EXHIBIT L – LAND USE MAP

Land Use Map_v1.pdf Markup Summary 8-30-2022

Zone Map 111

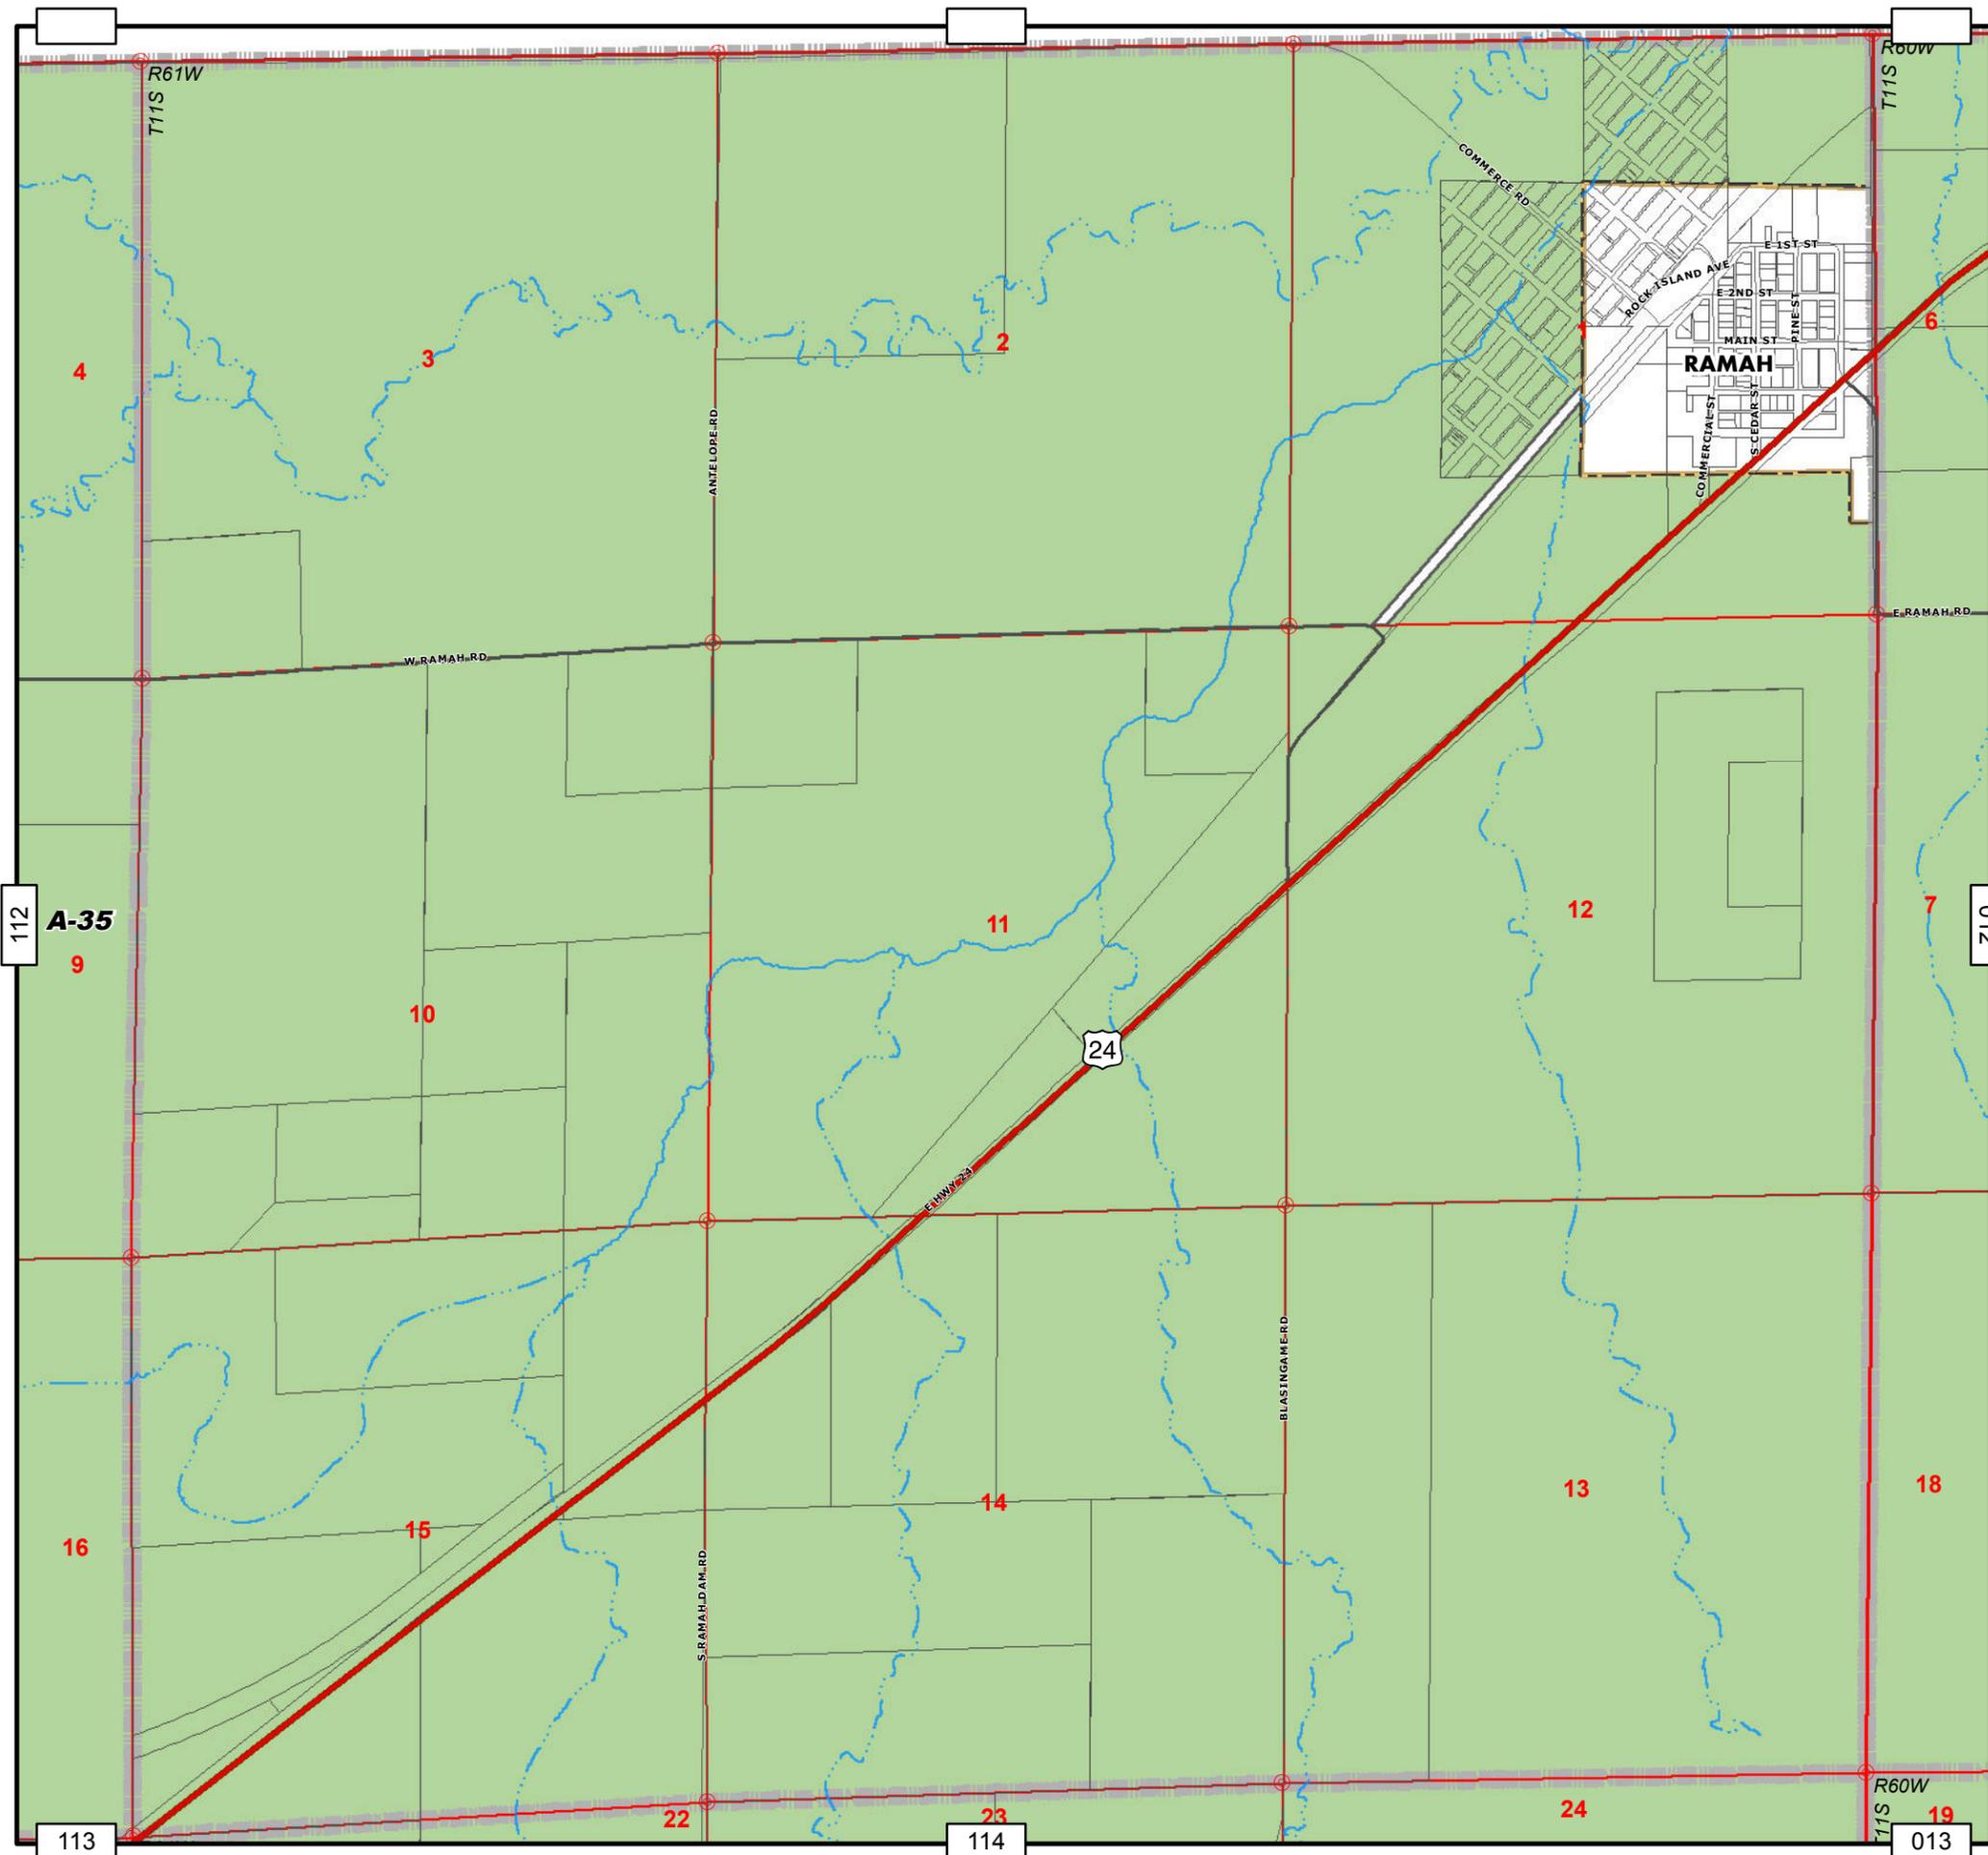
provide outline of project area: lift station, ponds, etc, sewer lines... identify if the nearby properties are vacant or what structures are erected and what they are used for. This is a zone map.

Zone Map 012

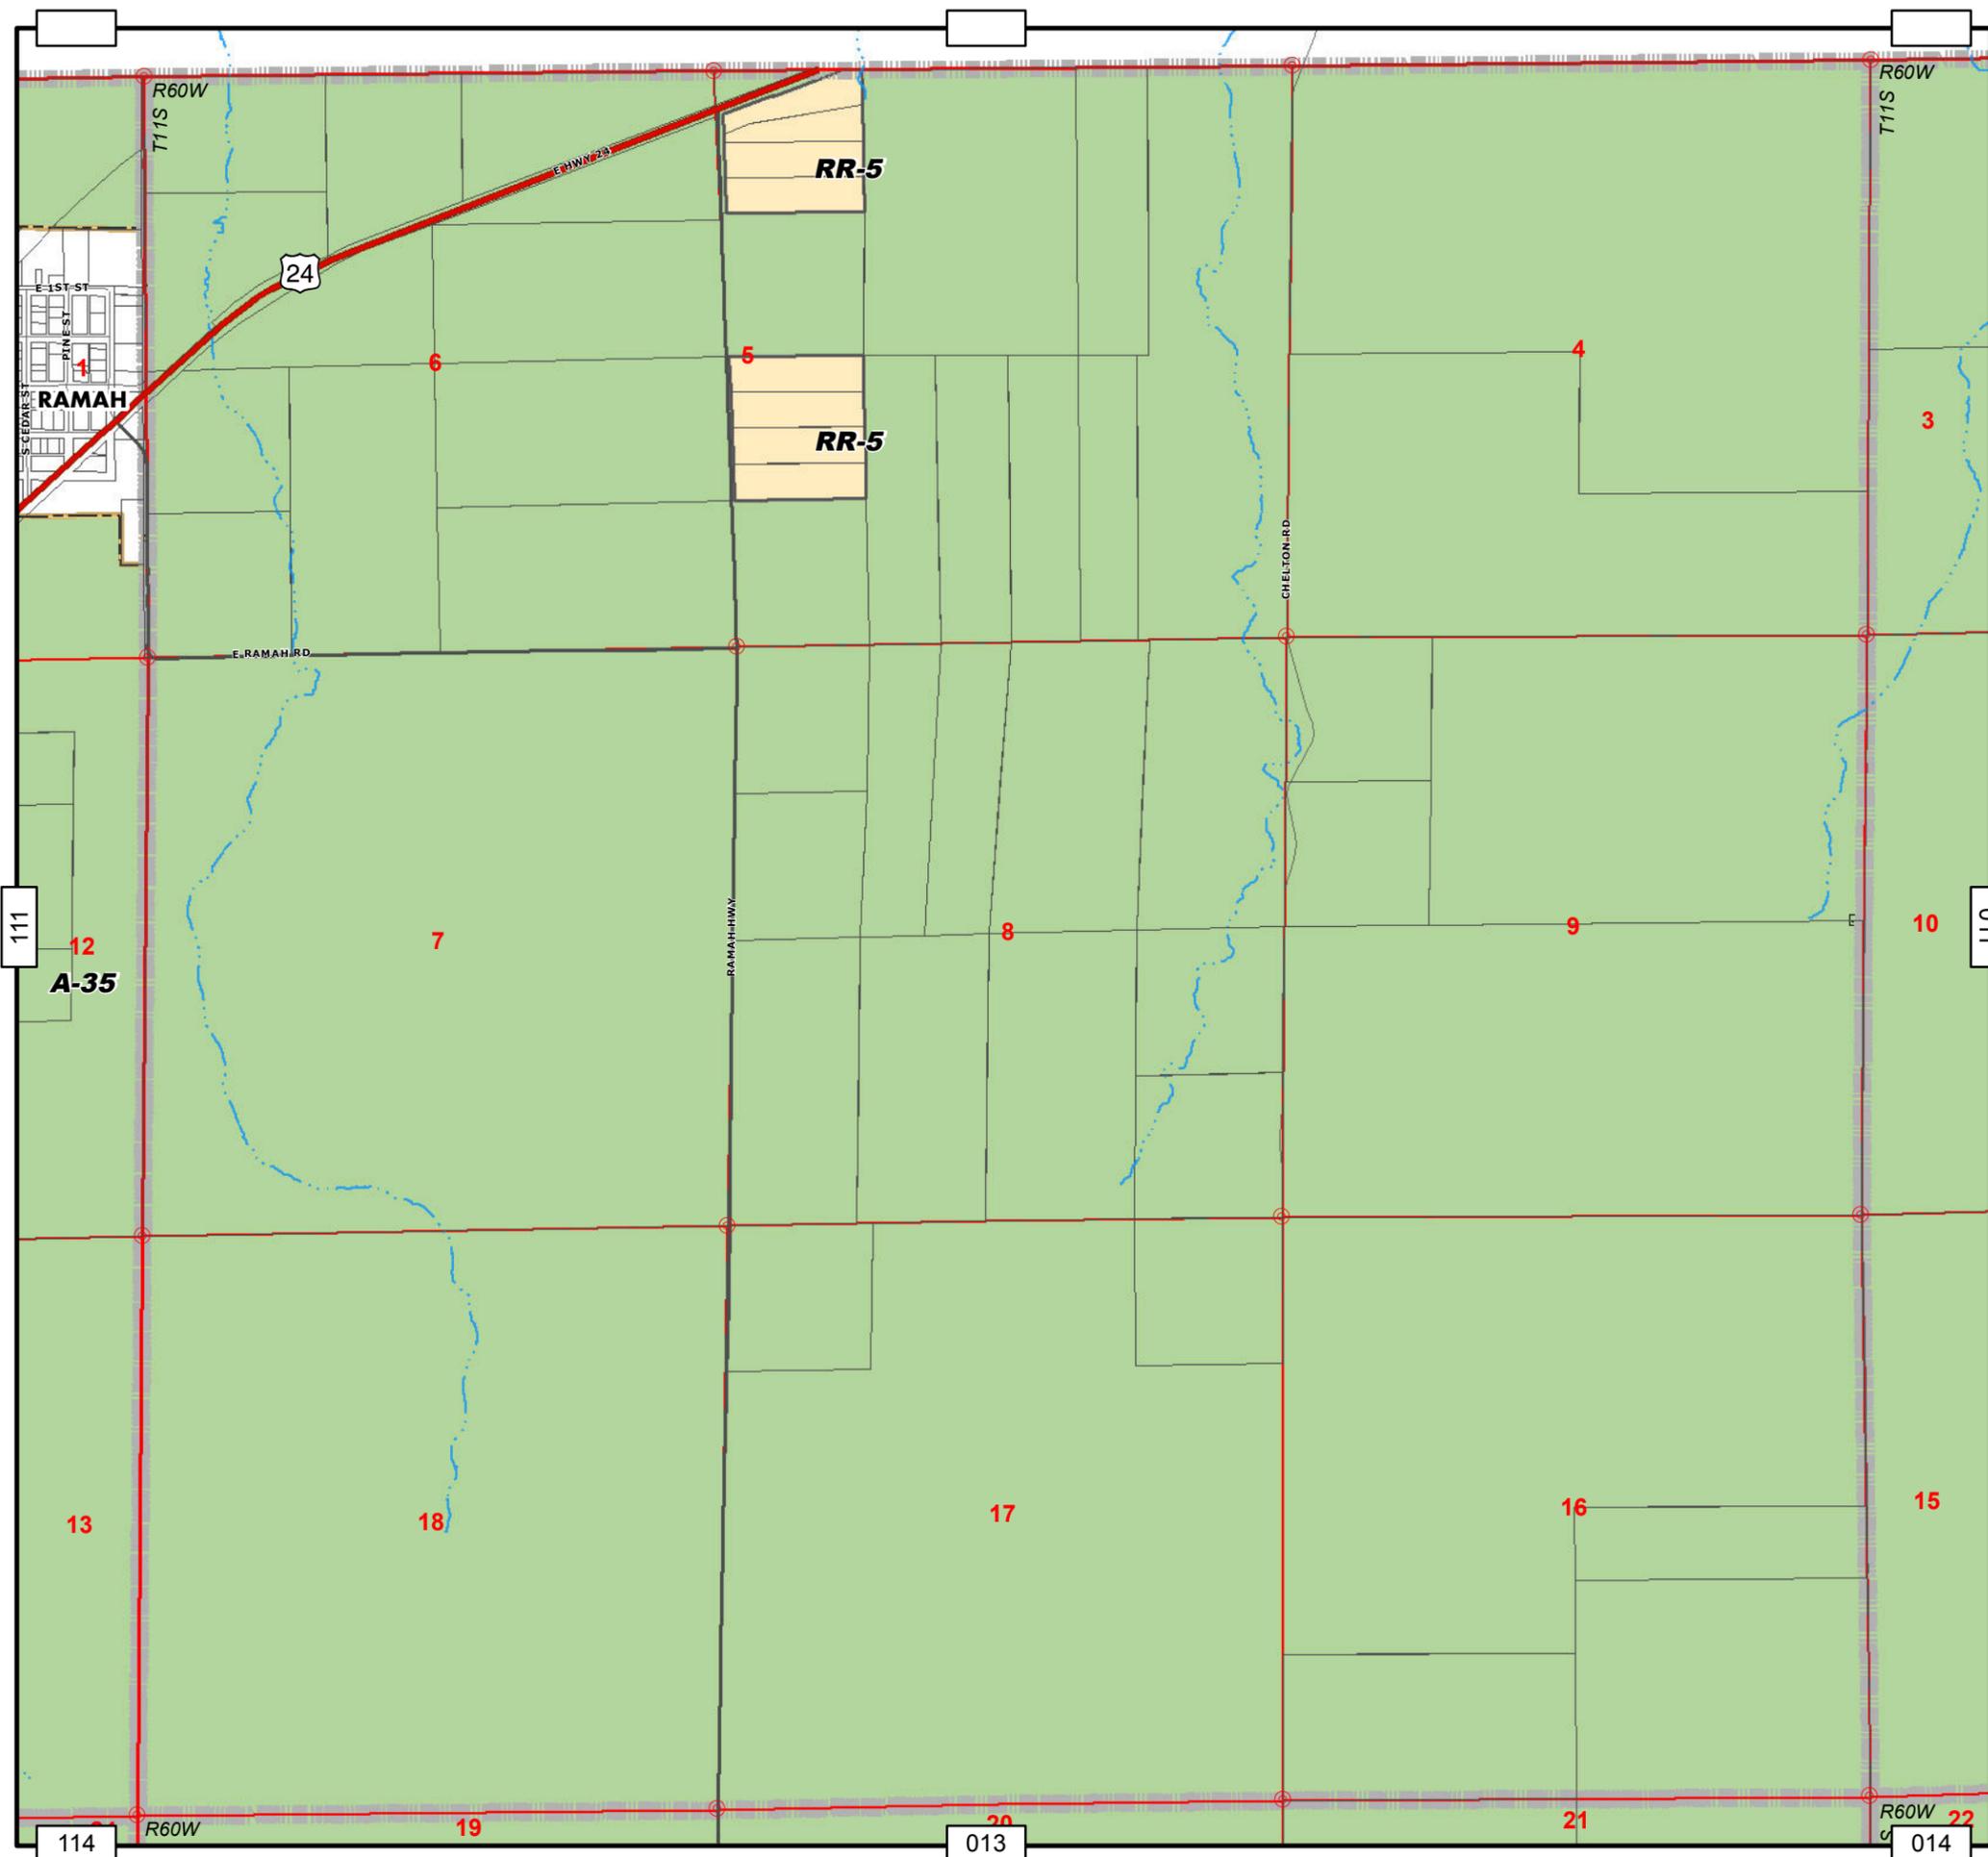
provide outline of project area and sewer lines...
identify if the nearby properties are vacant or what
structures are erected and what they are used for.
This is a zone map.

provide outline of project area: lift station, ponds, etc, sewer lines... identify if the nearby properties are vacant or what structures are erected and what they are used for. This is a zone map.
